From: Simon Davis
Sent: 17 June 2021 15:02
To: [REDACTED]
Cc: [REDACTED] Christopher Best <christopher.best@arun.gov.uk>
Subject: RE: AL/49/21/DOC - Springfield, Hook Lane

Subject: AL/49/21/DOC - Springfield, Hook Lane

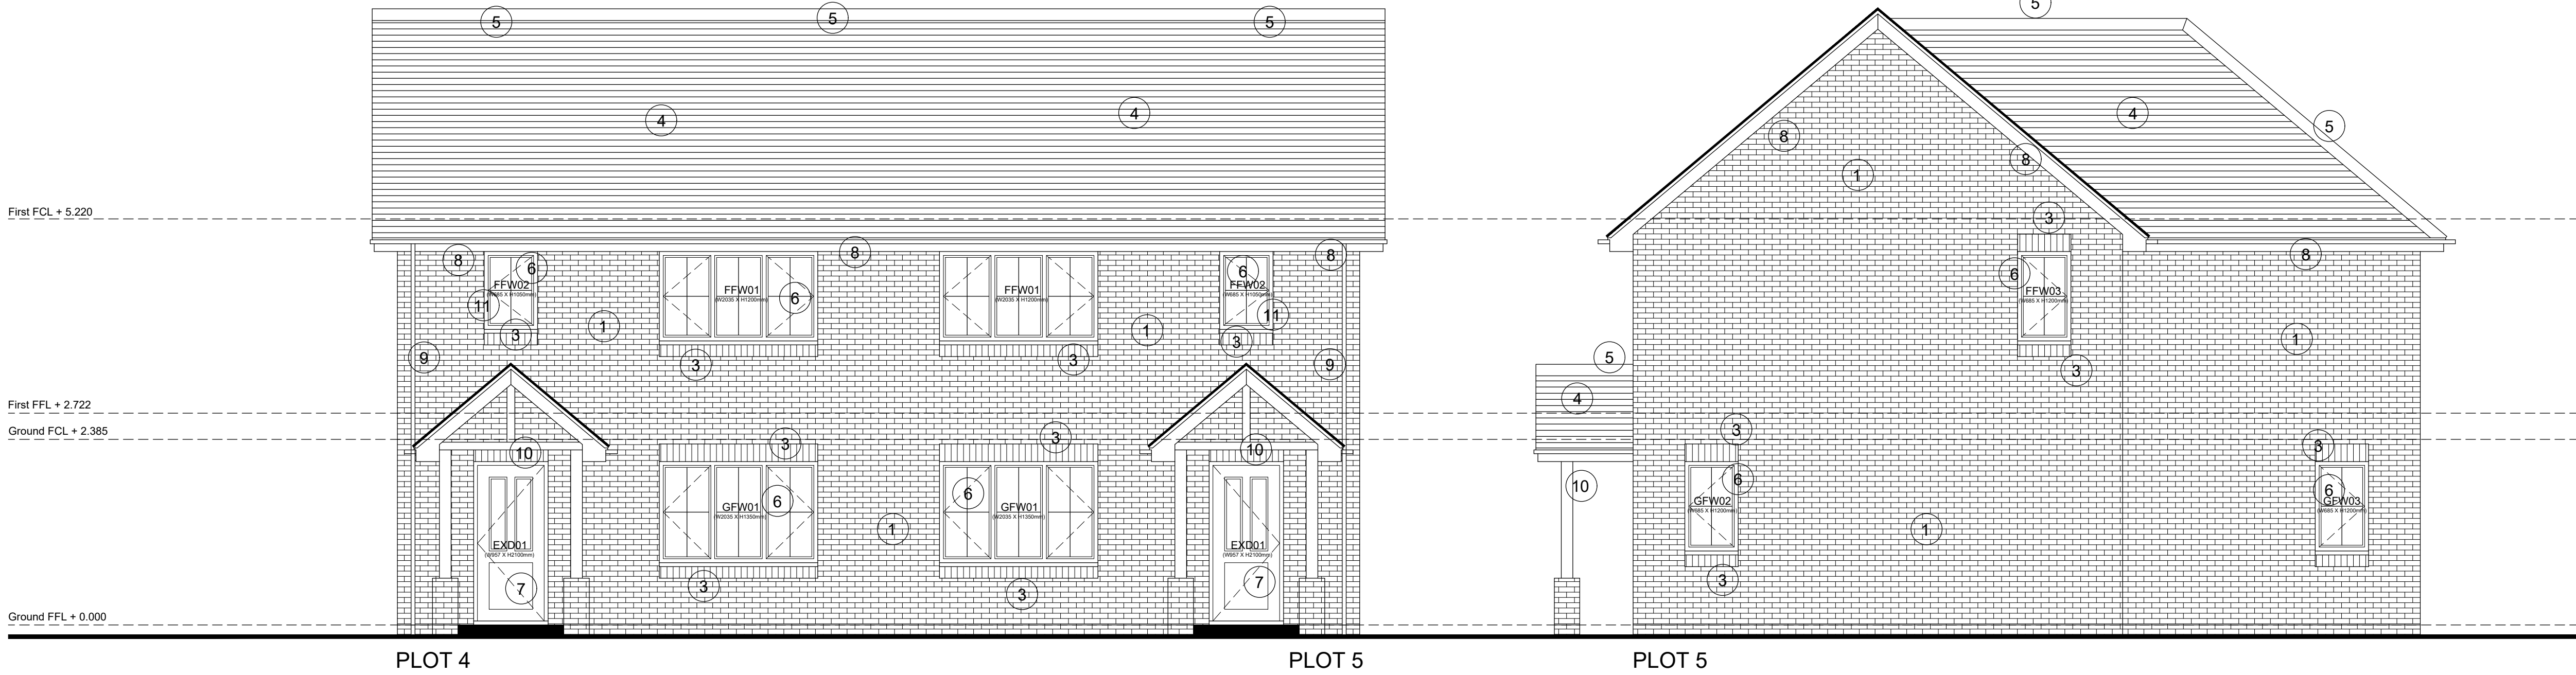
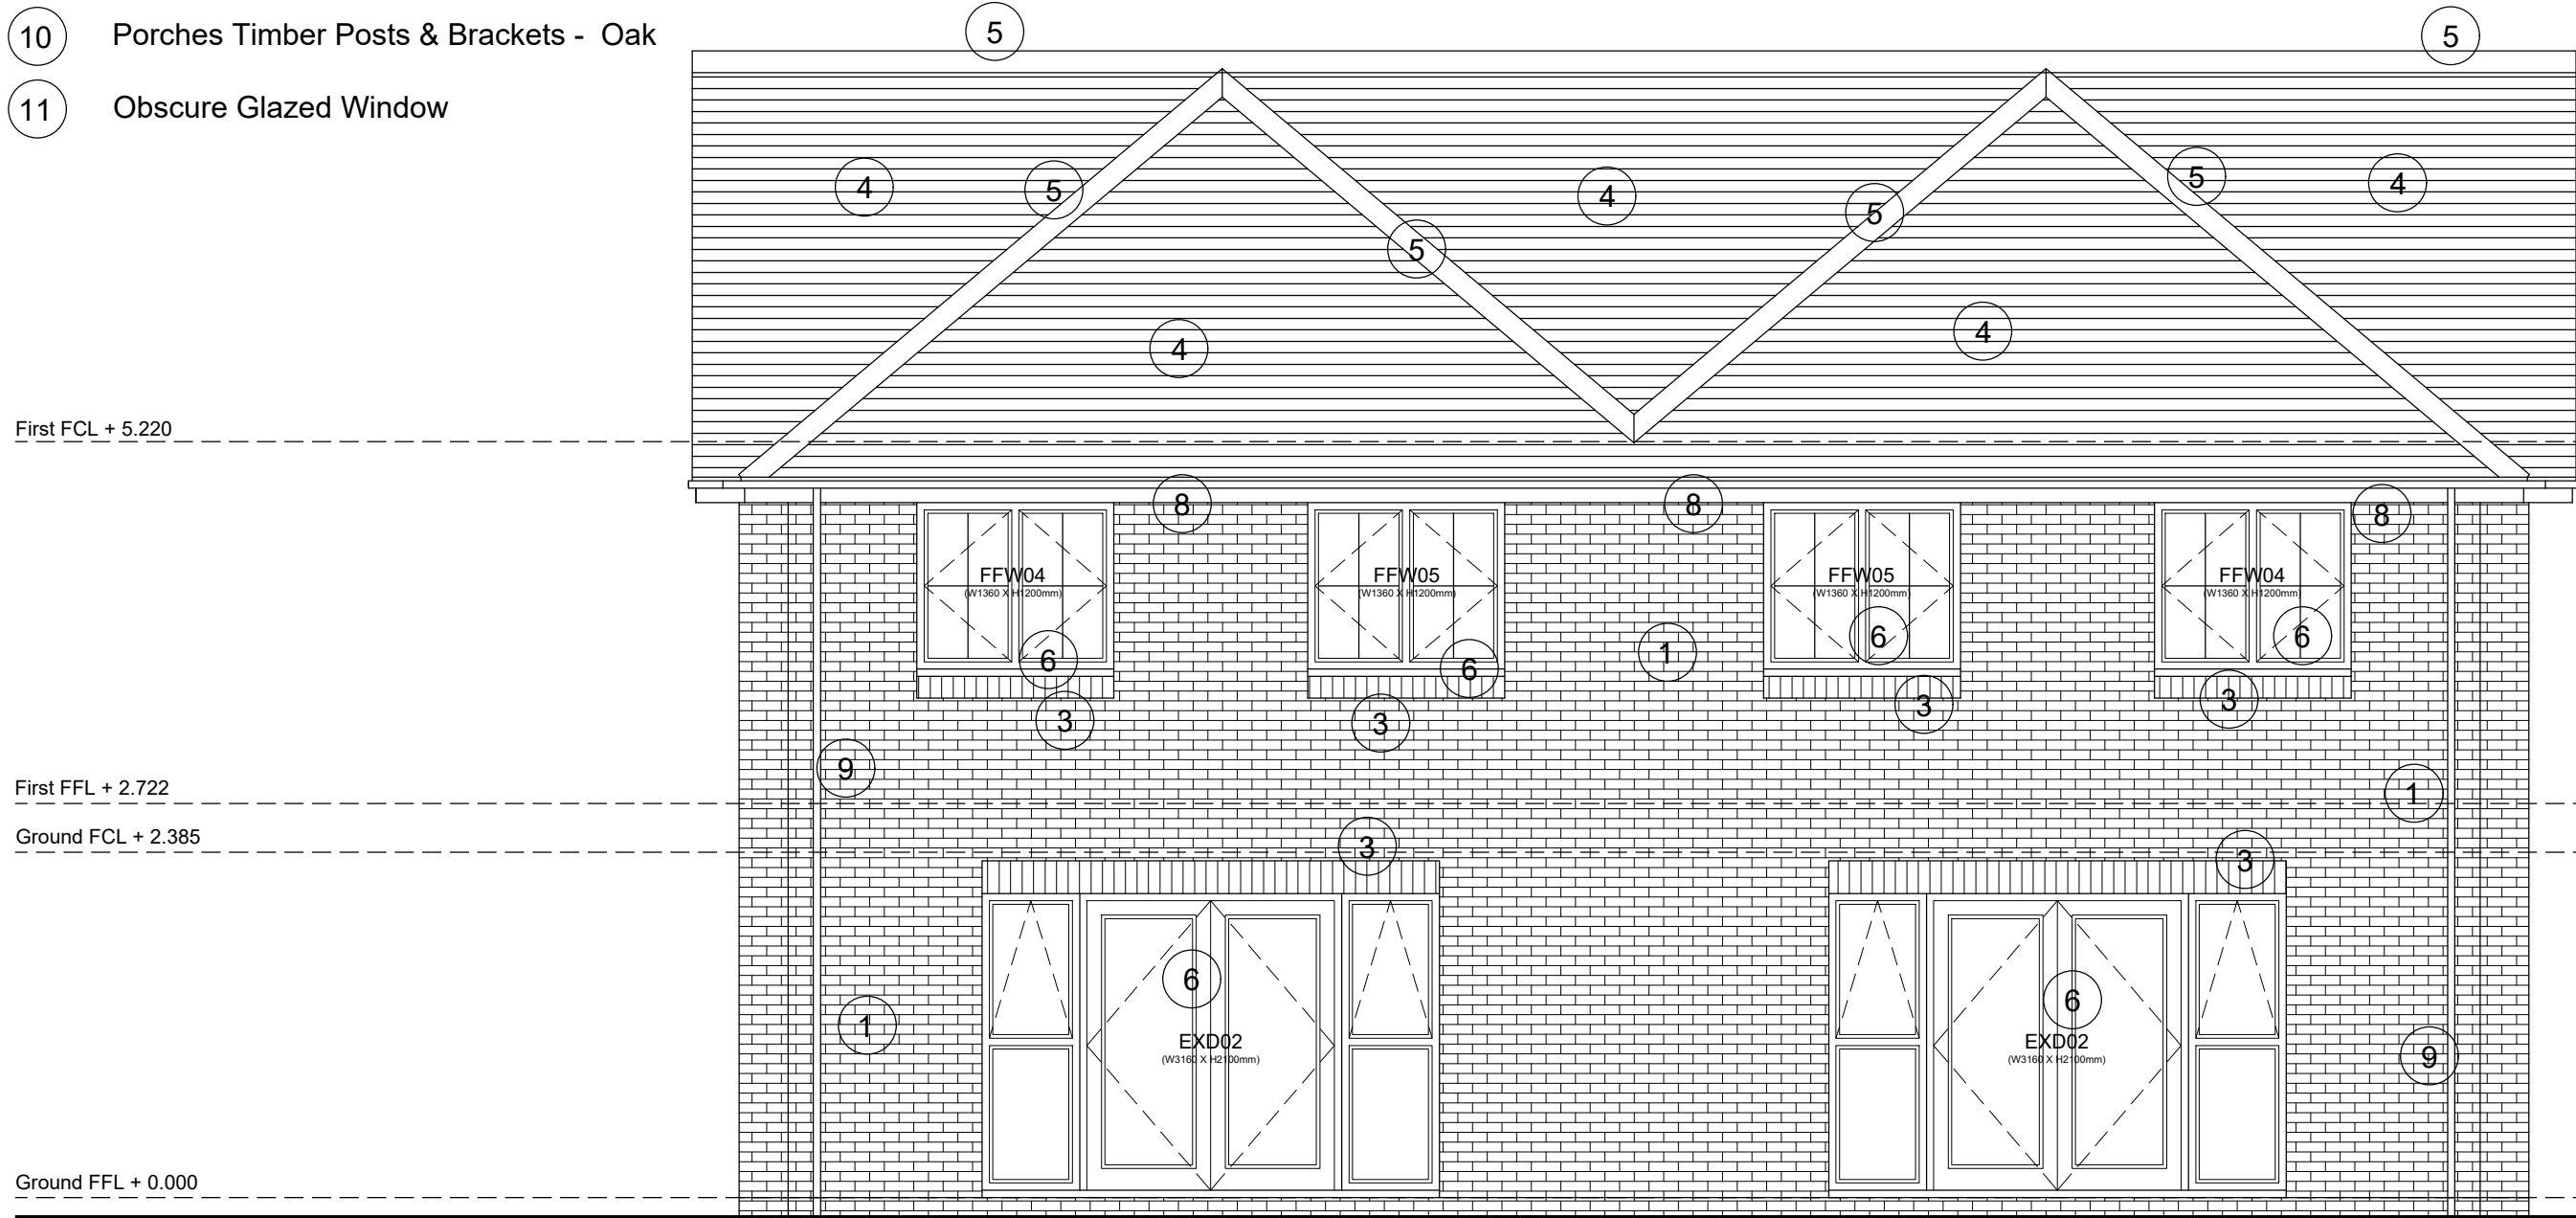
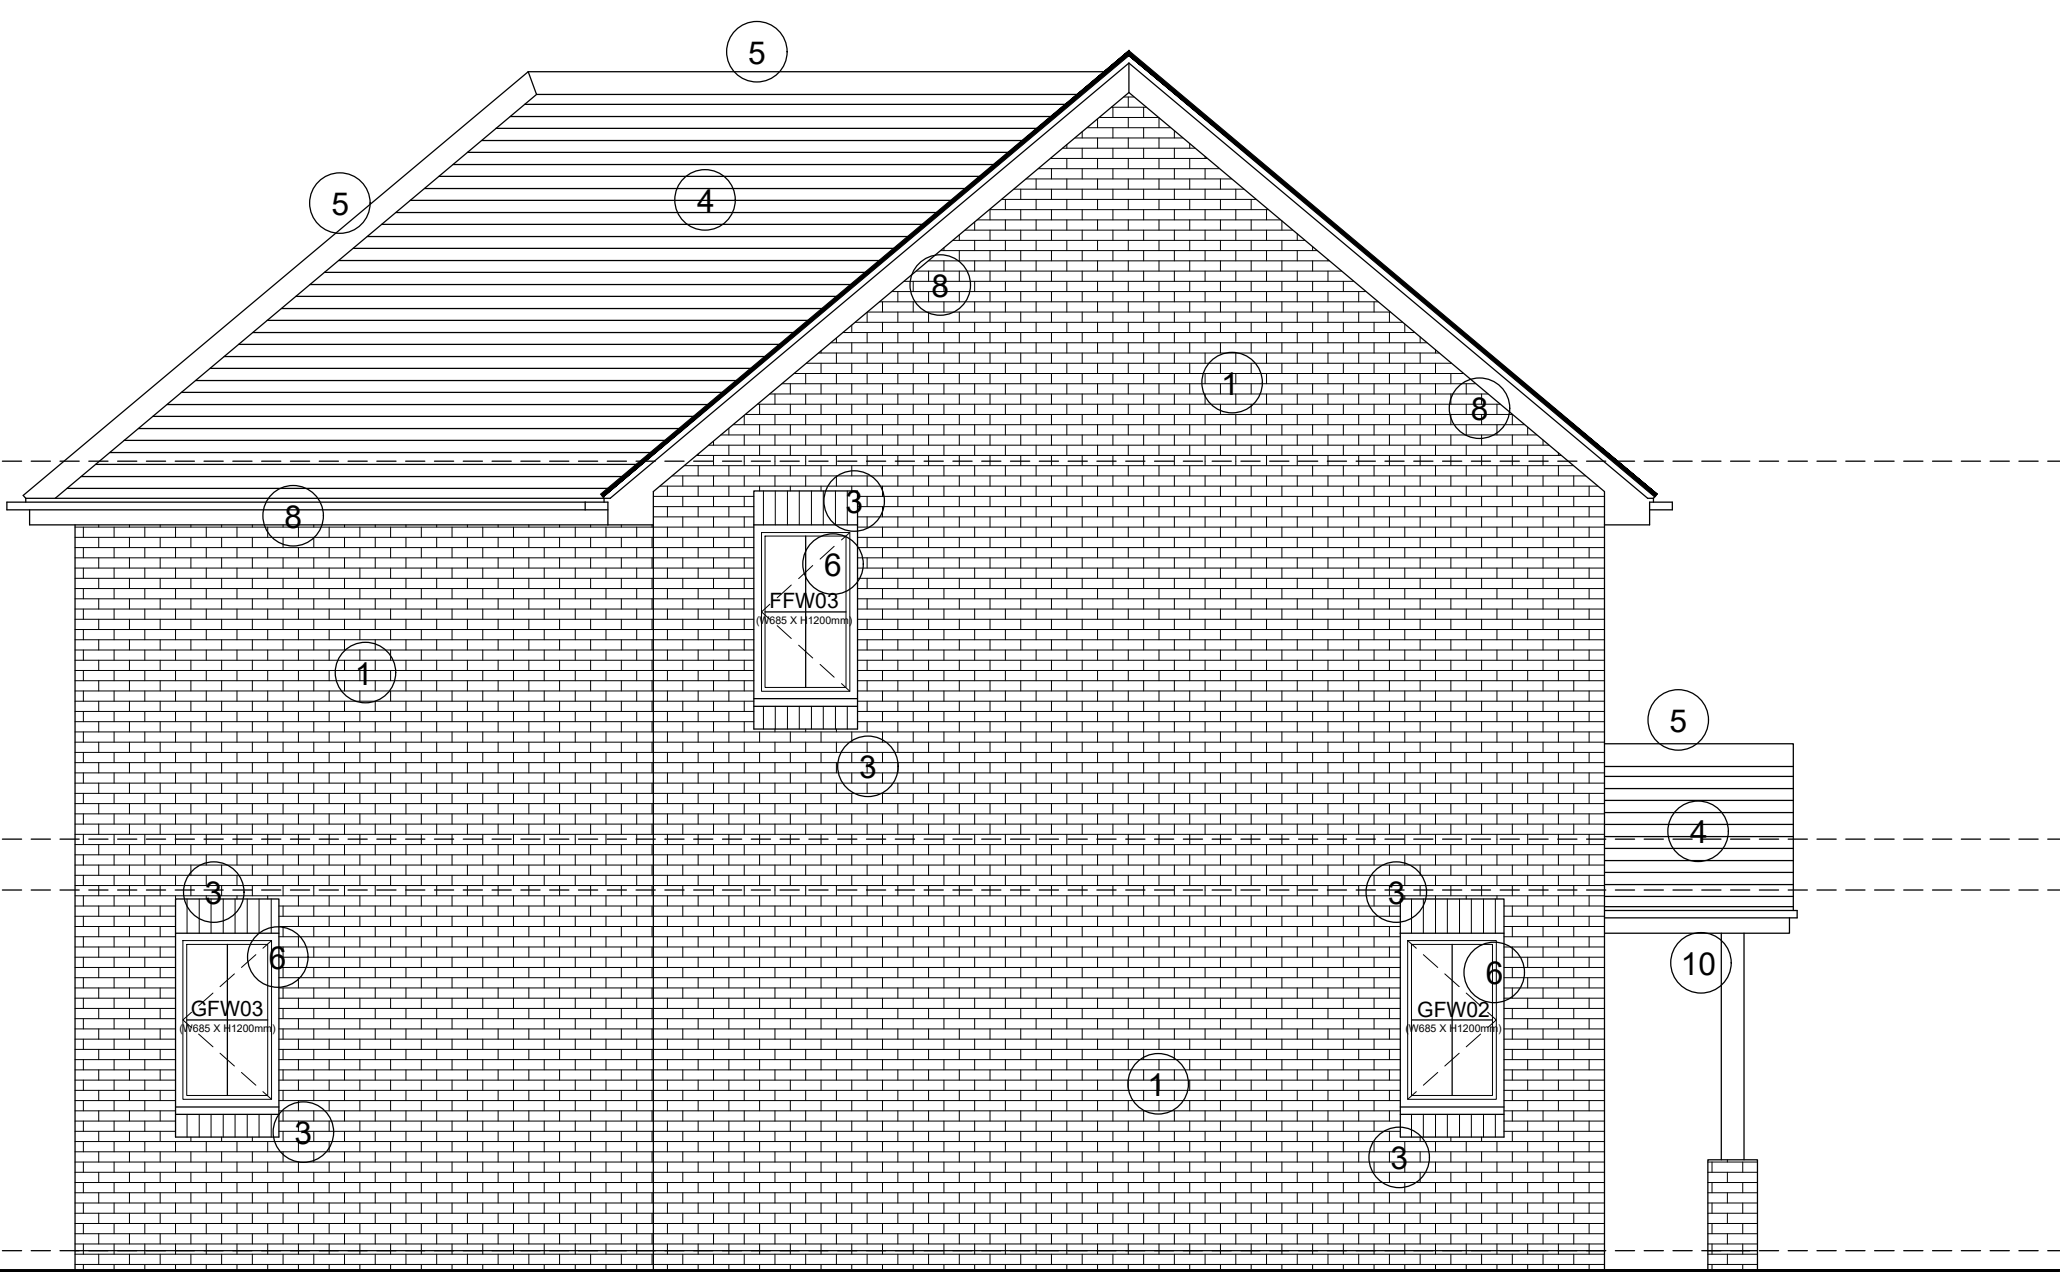
14	I have accepted the amended plans regarding the materials and I will be able to approve this.
15	As 13.
16	I did request that you respond within 10 days of my email dated 07/06 which you did meet. However, I have looked at the condition wording and see that it requires 24 new native trees but the plan provided shows only 12. I will therefore be refusing this condition on the basis of not meeting the condition requirements.
18	The use of Air Source Heat Pumps (as shown in the spec and the associated plan) is acceptable but there is no information to meet this part of the condition “.. <i>demonstrate that the development will achieve energy efficiency measures that reflect the current standards applicable at the time of submission</i> ...” It is not appropriate to just propose
